A National Amenity Society

29th July 2025

Lower Reaps Farm, Whinney Lane, Mellor , BB2 7EL. Application No. /2025/0508 and 3/2025/0507

ground floor plan

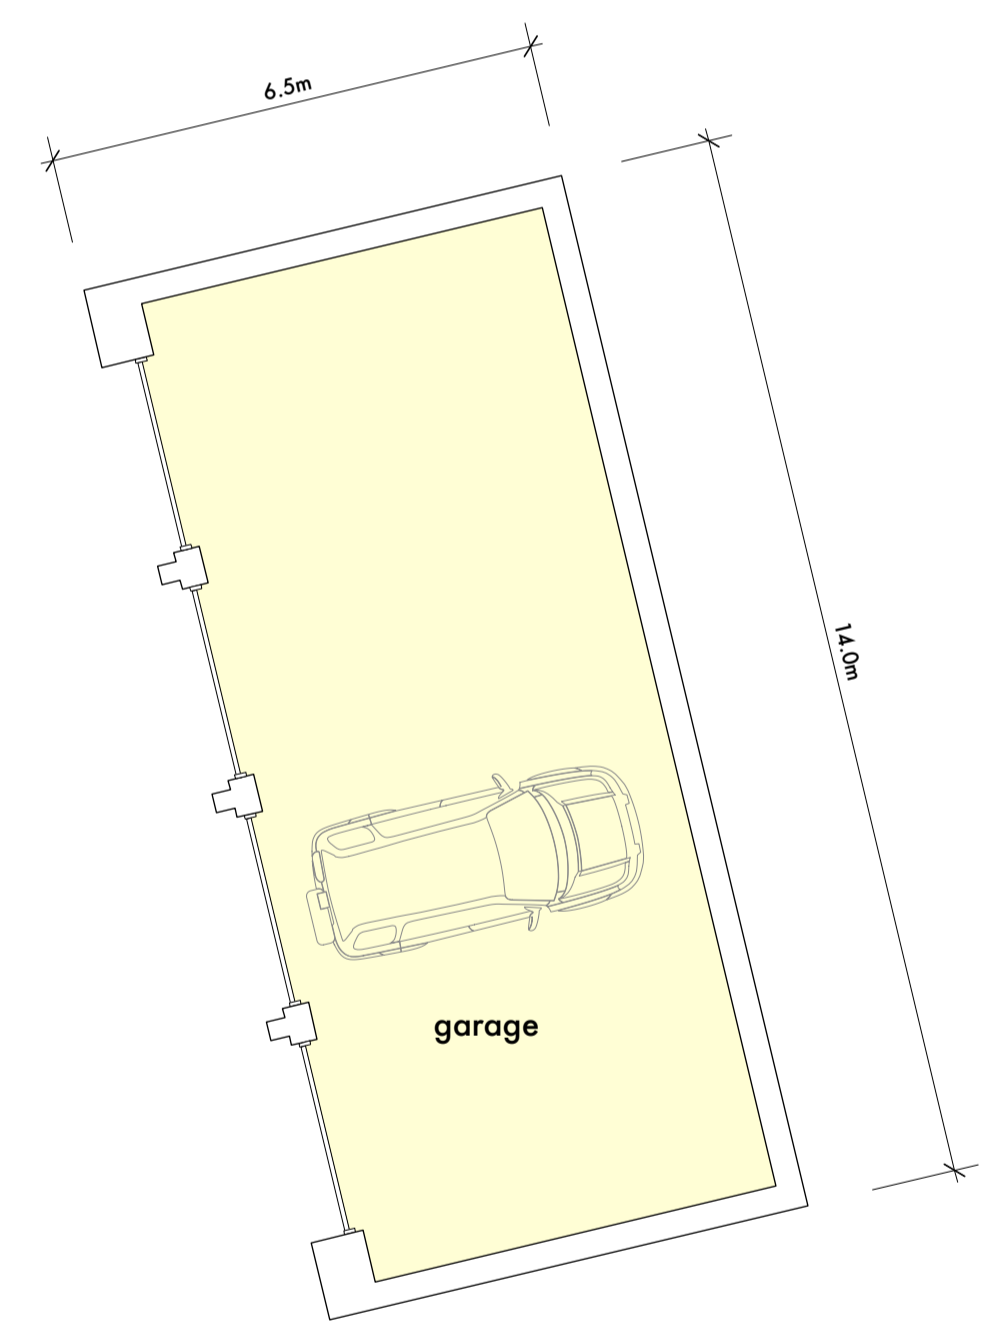
It is not clear what interventions are proposed for the ground floor, although photos demonstrate an existing agricultural use which suggests a domestic floor screed will be part of the proposed works. For the reasons set out above, it is important that any consented underfloor heating system should be achieved in a limecrete screed. The CBA have recently reviewed proposals for similar works at a farmhouse in Lancashire. The applicants may find the Planning Statement, which contains manufacturers details in the appendix, helpful in establishing appropriate details to their proposals. [Writtenstone Farm, PR3 2ZN, 3/2025/0511](#)

south elevation

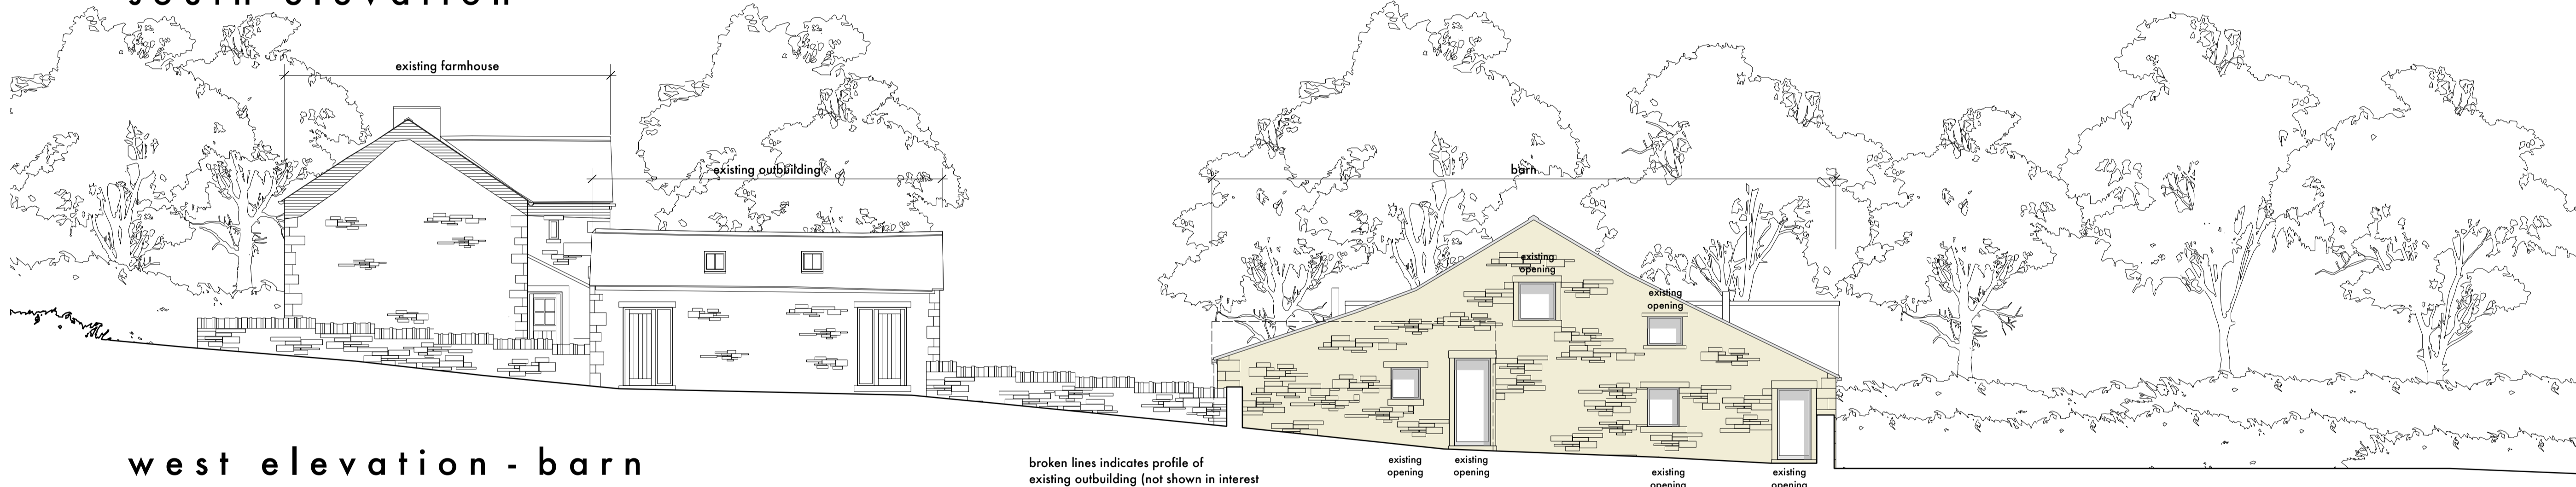
We are concerned that the three sets of bifold doors proposed in the southern shippon will erode the agricultural character of the building (and site) on an elevation that is prominent within the landscape. Being south facing this large quantity of glass will create highly visible glare. We therefore advise that any new openings to this elevation are kept to a minimum and are less overtly domestic in character.
